WEST SUSSEX COUNTY COUNCIL CONSULTATION

TO:	Arun District Council FAO: Simon Davis
FROM:	WSCC - Highways Authority
DATE:	19 October 2021
LOCATION:	Land adjacent to Oak Bank, Wandleys Lane, Walberton, BN18 0QR
SUBJECT:	WA/93/21/PL New detached dwelling & detached garage. This site is in CIL Zone 3 & is CIL Liable as new dwelling.
DATE OF SITE VISIT:	N/A
RECOMMENDATION:	Advice
S106 CONTRIBUTION TOTAL:	N/A

Site Block Plan 1:200

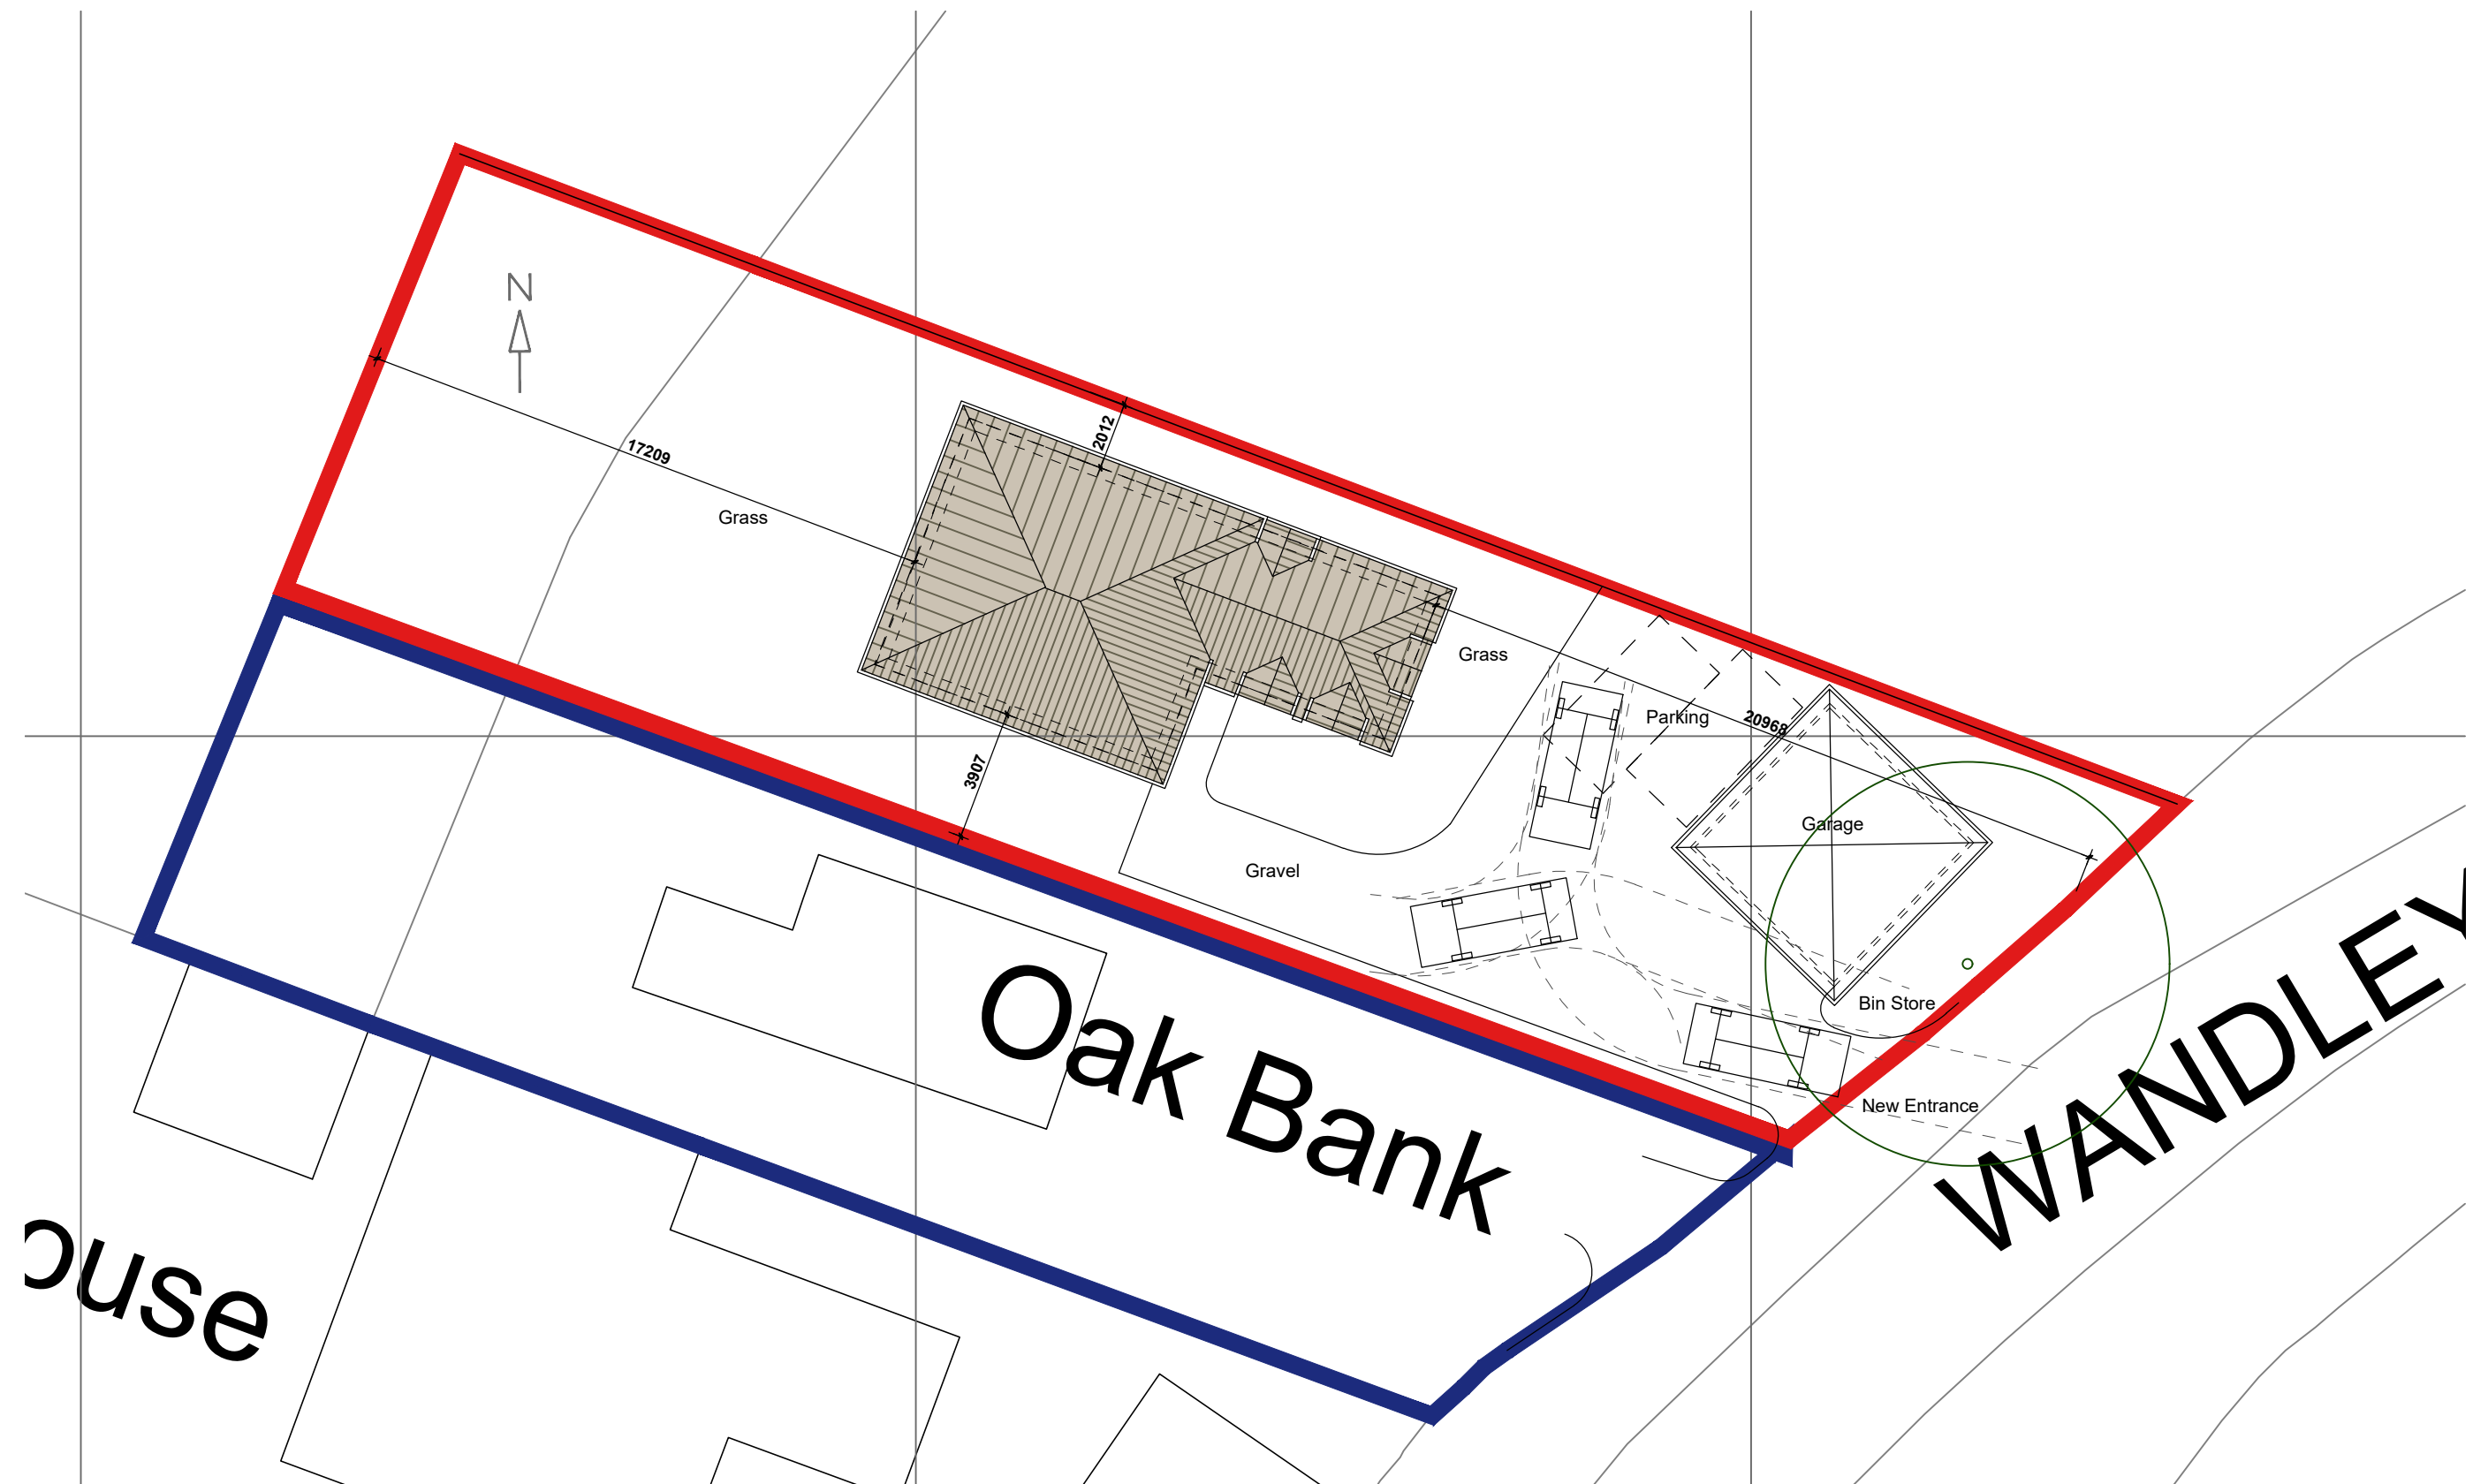
The applicant proposes a new vehicular access on to Wandleys Lane. From inspection of the plans and WSCC mapping, there are no apparent visibility concerns with the proposed point of access on to the maintained highway. In addition, the LHA does not anticipate that the addition of one dwelling would give rise to a significant material intensification of movements to or from the site.

The applicant proposes a double-bay garage and two additional parking bays for this development, totalling to four car parking spaces. Under Arun Parking Standards, the LHA would expect a parking provision for at least three parking spaces for a dwelling of this size in this location. Therefore, the LHA considers the proposed parking provision to be sufficient. The applicant has also demonstrated that on-site turning is achievable, allowing cars to exit the site in a forward gear.

No part of the development shall be first occupied until such time as the vehicular access serving the development has been constructed in accordance with the details shown on the drawing titled "Proposed Feasibility Sketch Plan and Elevation" and numbered "21034/001P B".

Garage Plan

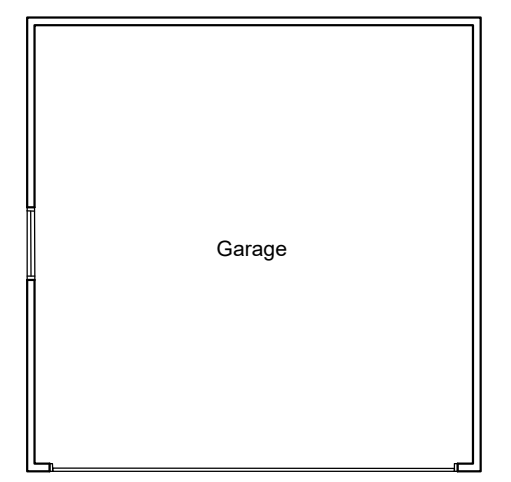
The LHA does note that the proposed double-bay garage falls slightly short of the minimum internal specifications for double-bay garages of 6m x 6m as set out in Manual for Streets (MfS). The garage as proposed has approximate internal dimensions of 5.8m x 5.8m. Therefore, the LHA advises the applicant to enlarge the garage to meet MfS specifications, to ensure modern vehicles can fit inside. Notwithstanding this, the LHA is satisfied that sufficient parking provision is available on-site.

LPA believes cycle parking is justifiable, the applicant should demonstrate this in the form of covered and lockable cycle storage, in accordance with Arun Parking Standards. As mentioned above, if the garage is enlarged to MfS specifications, the LHA can consider the garage for cycle parking provision.
